**From:** Jennifer Thompson  
**To:** Jean Fraser  
**Date:** 4/4/2014 1:29 PM  
**Subject:** Re: Plat and Condo docs for 118 Congress (sent around end of last week)

Re PLAT: There are couple of little things he has not addressed (listed in your memo as attached to the letter of approval) but they are minor. He could remove a couple of the conditions (I had told him that before he submitted it). He has not put in the book and page of the condo docs nor details of the plan showing street trees (see Note 19)- I would prefer the street tree locations to be correct and identified on the plat but will defer to you on this (and I know some plats have not included them- but here they are a big deal as the applicant will be looking after them and has relocated them all and Jeff Tarling is not happy). In the past (re mixed use condos/subdiv) Danielle has requested the floorspace numbers be noted- I attach the plat for 321 Commercial which though bigger appears a good example in respect of many of these items.

SUBDIVISION RECORDING PLAT
C1.0

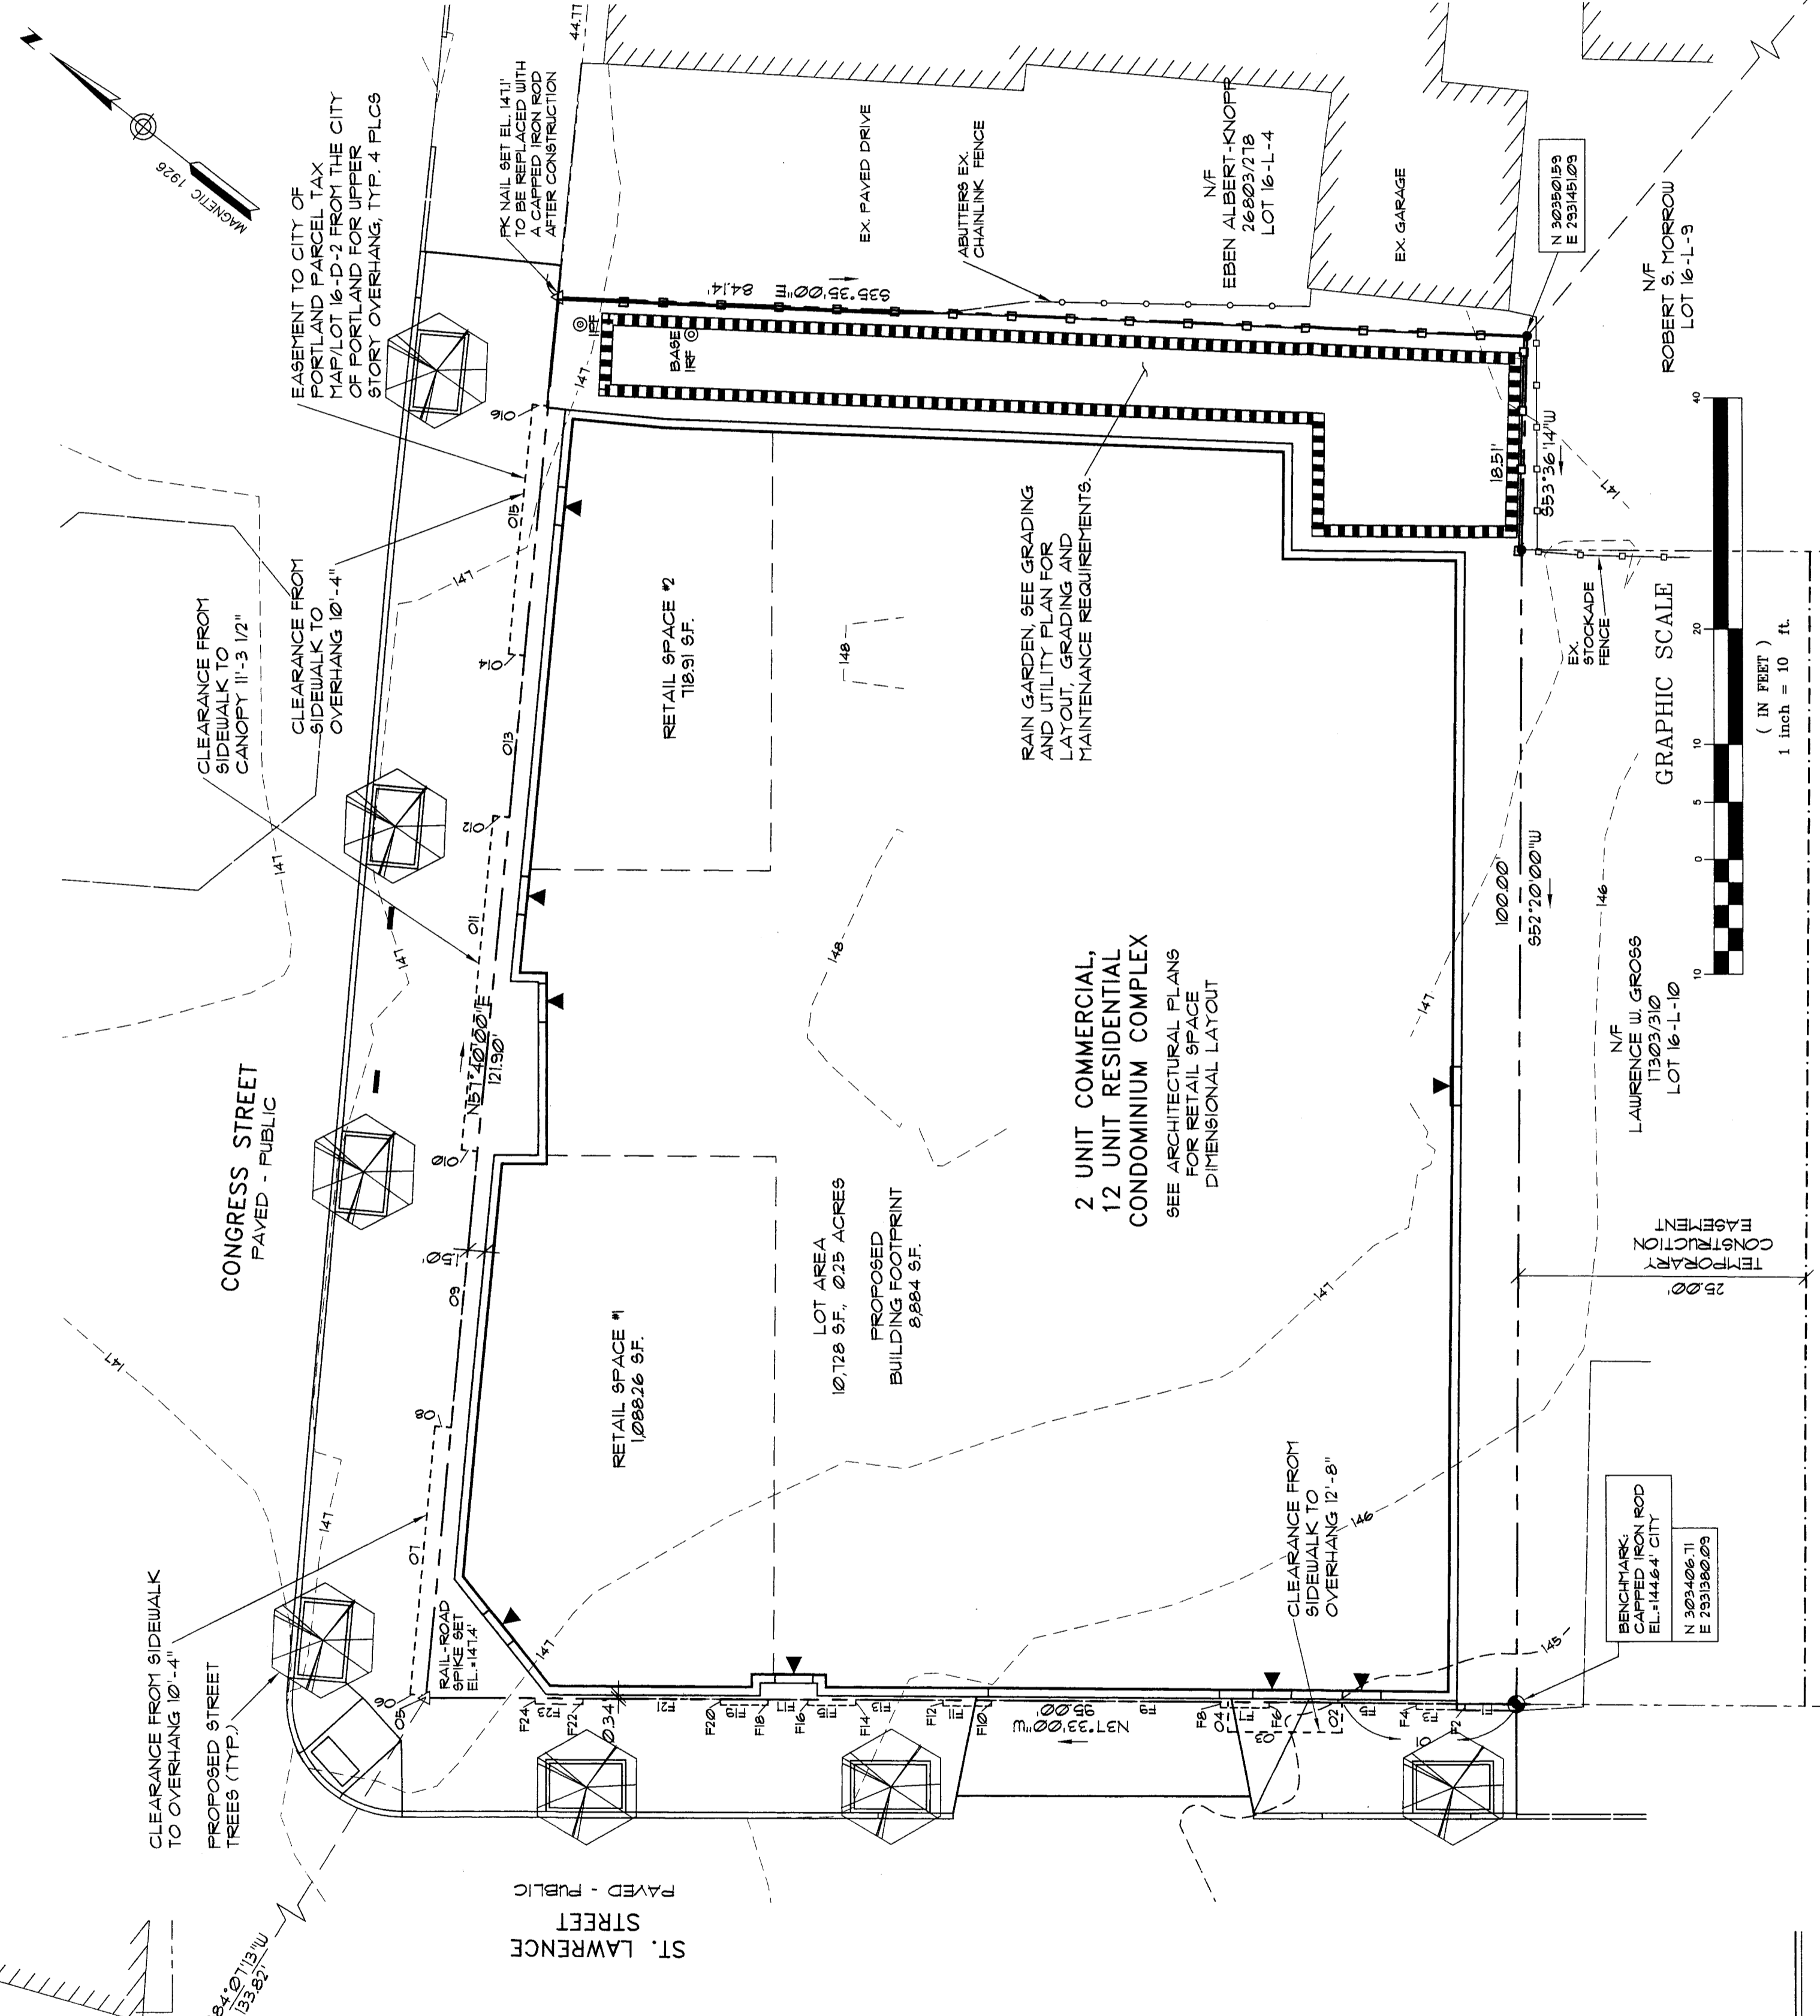
Rather than reference the condo docs for maintenance, snow and trash removal responsibilities, I want those spelled out more clearly on the plat. The reference to the condo docs should also remain but I agree that the book and page need to be included. The Marriot plat you sent contains notes that are a good example of this requirement having been met.

Responsibility for maintenance of the rain garden needs to be included in the notes. It's not enough to refer to the grading and utility plan.

I agree that the required trees need to be indicated on the plat.

A question for you: is it typical to have a note that declares: "this project complies with conditions of Portland Code of Ordinances . . ." Note 21. That makes me nervous. I'd prefer to have that note start with: The developer/contractor, etc. must comply with . . .

That is, I'm a little uncomfortable having this document purport to declare conformance with the Code - that's a legal determination that I'm not sure should be established on a Plat - but if this is typical, please do let me know that.

On Note 22, the obligations of the association with respect to the licensed area should be included.

We previously asked them to show the existence of the parking level and number of spaces. Am I missing that?
